# Markup Summary

**Subject:** Callout  
**Page Label:** [4] 4 PHOTOMETRIC PLAN  
**Lock:** Locked  
**Status:**  
**Checkmark:** Unchecked  
**Author:** dsdkendall  
**Date:** 4/26/2018 3:32:10 PM  
**Color:** ■  
**Layer:**  
**Space:**

PHOTOMETRIC PLAN

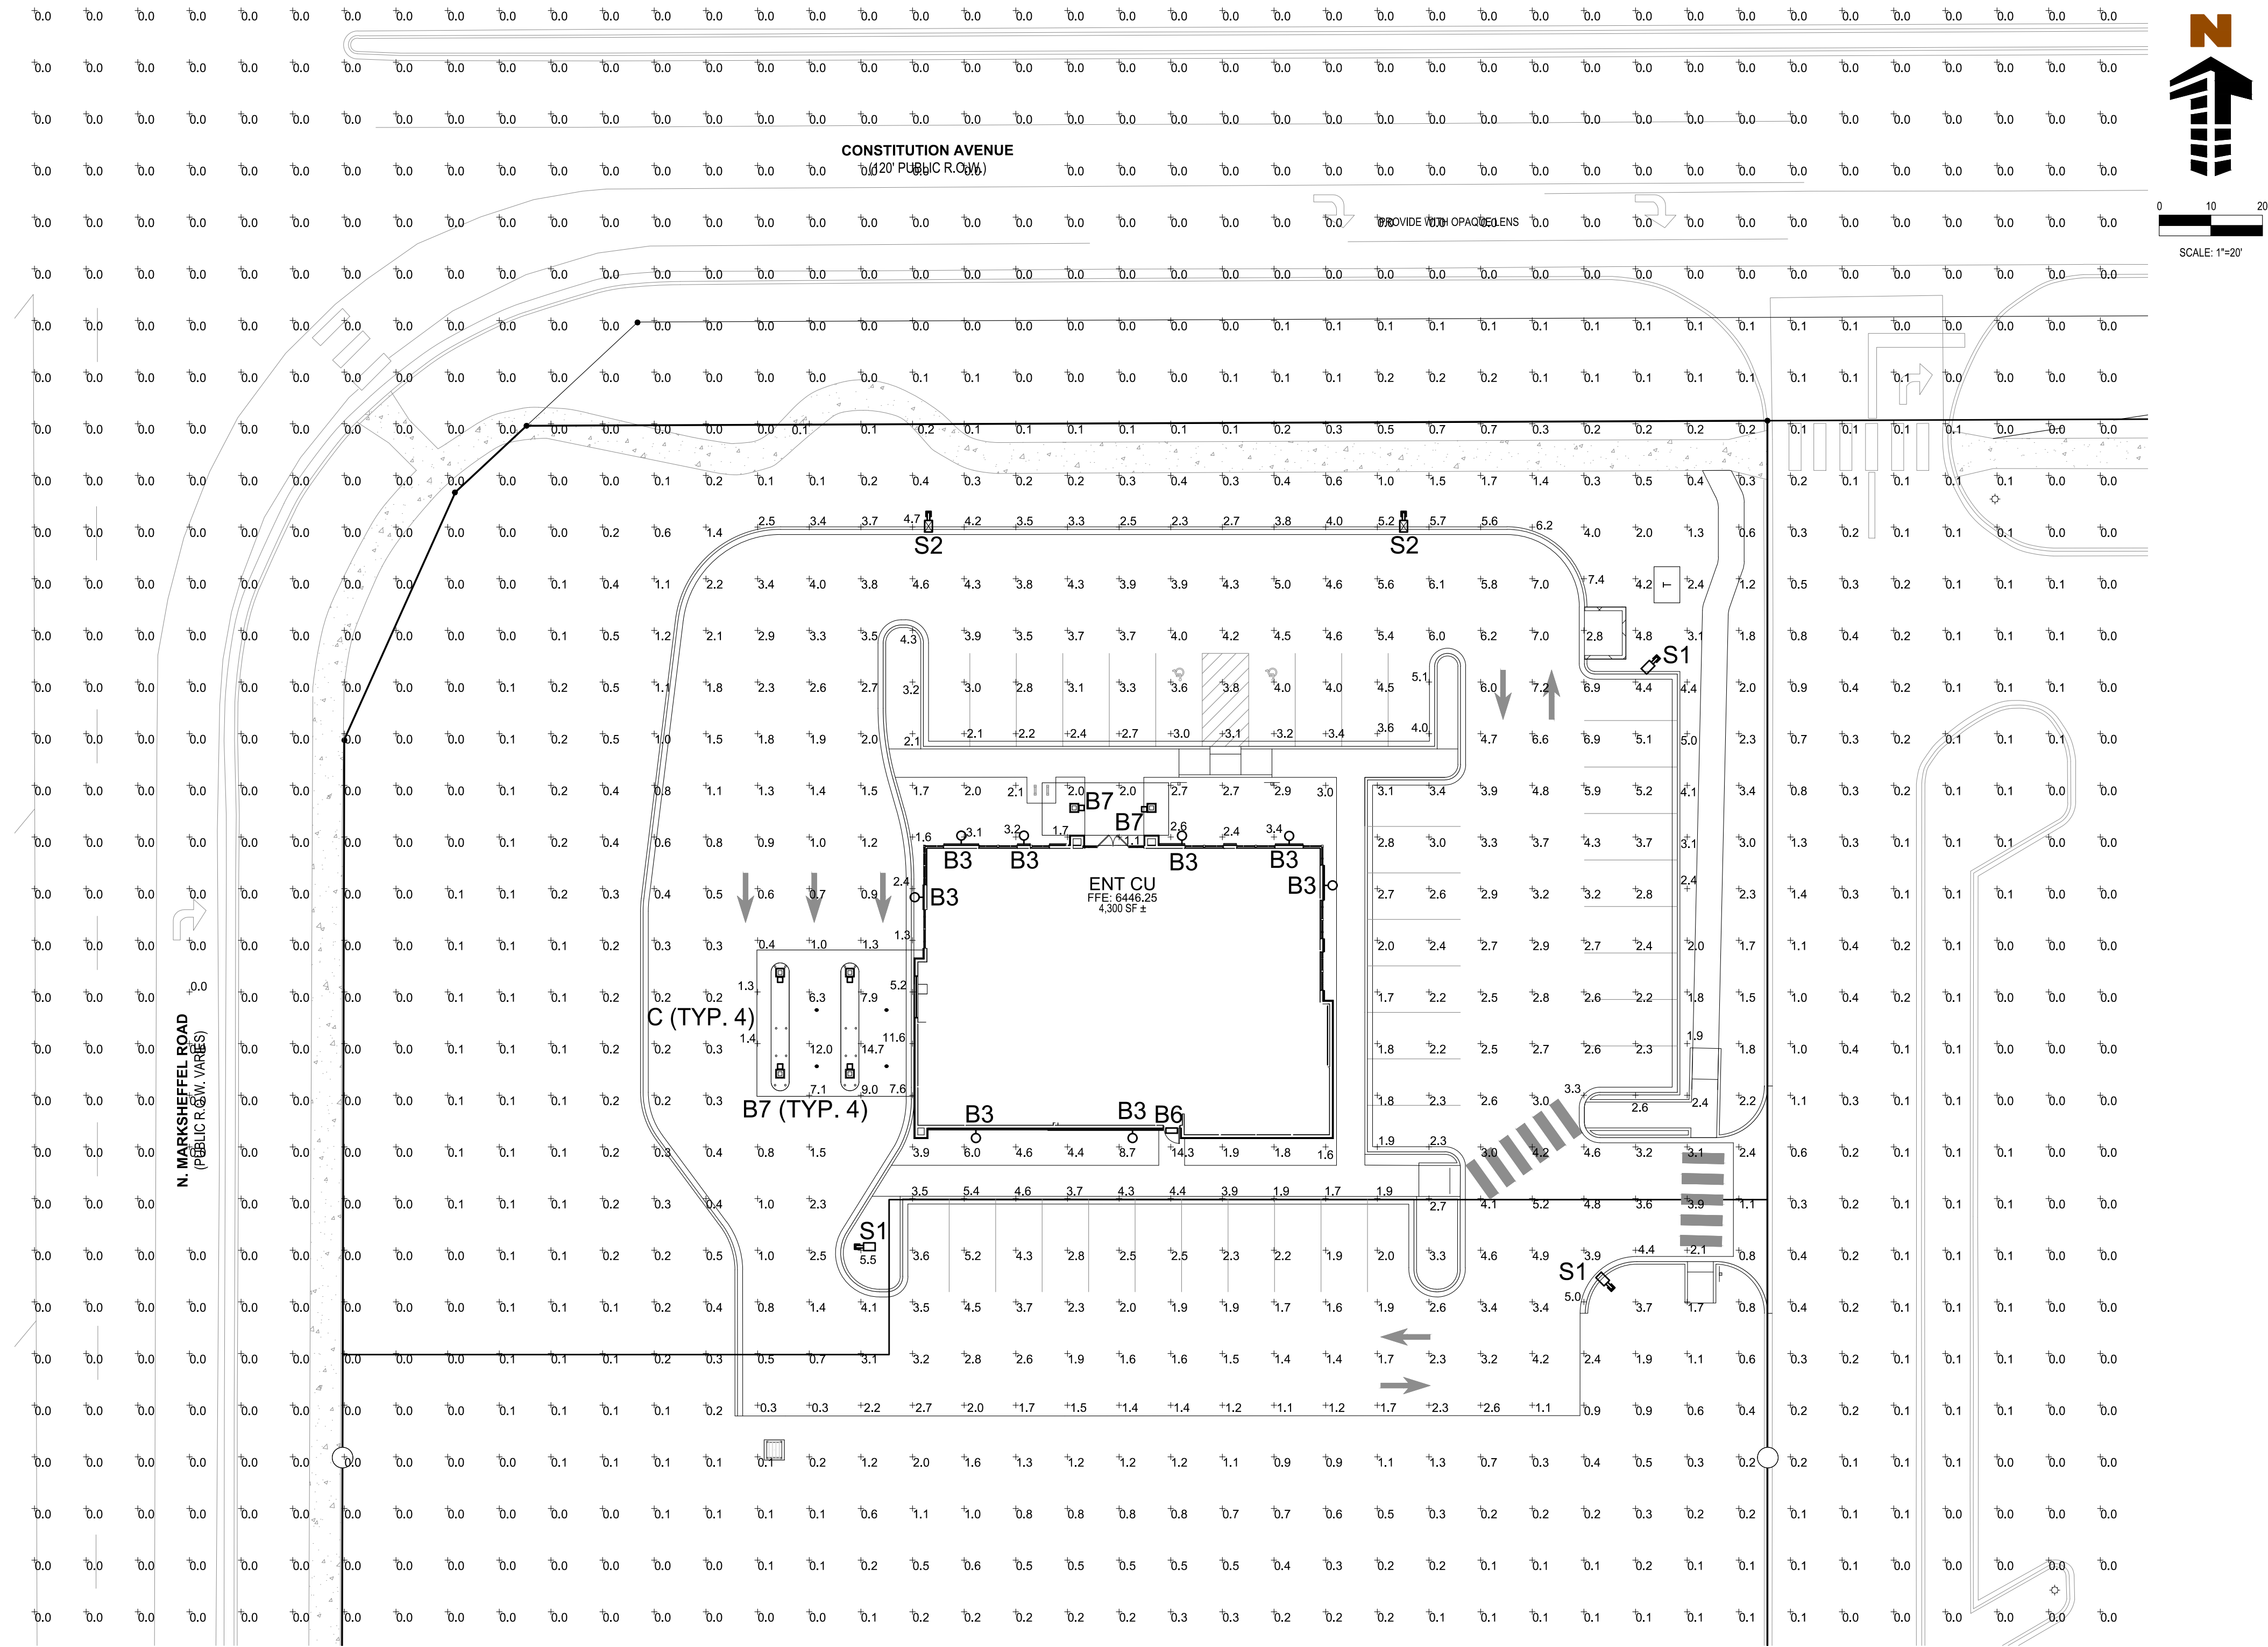
Poles can be no taller than 15 feet unless they are parking lot fixtures, then 20 feet is allowed.
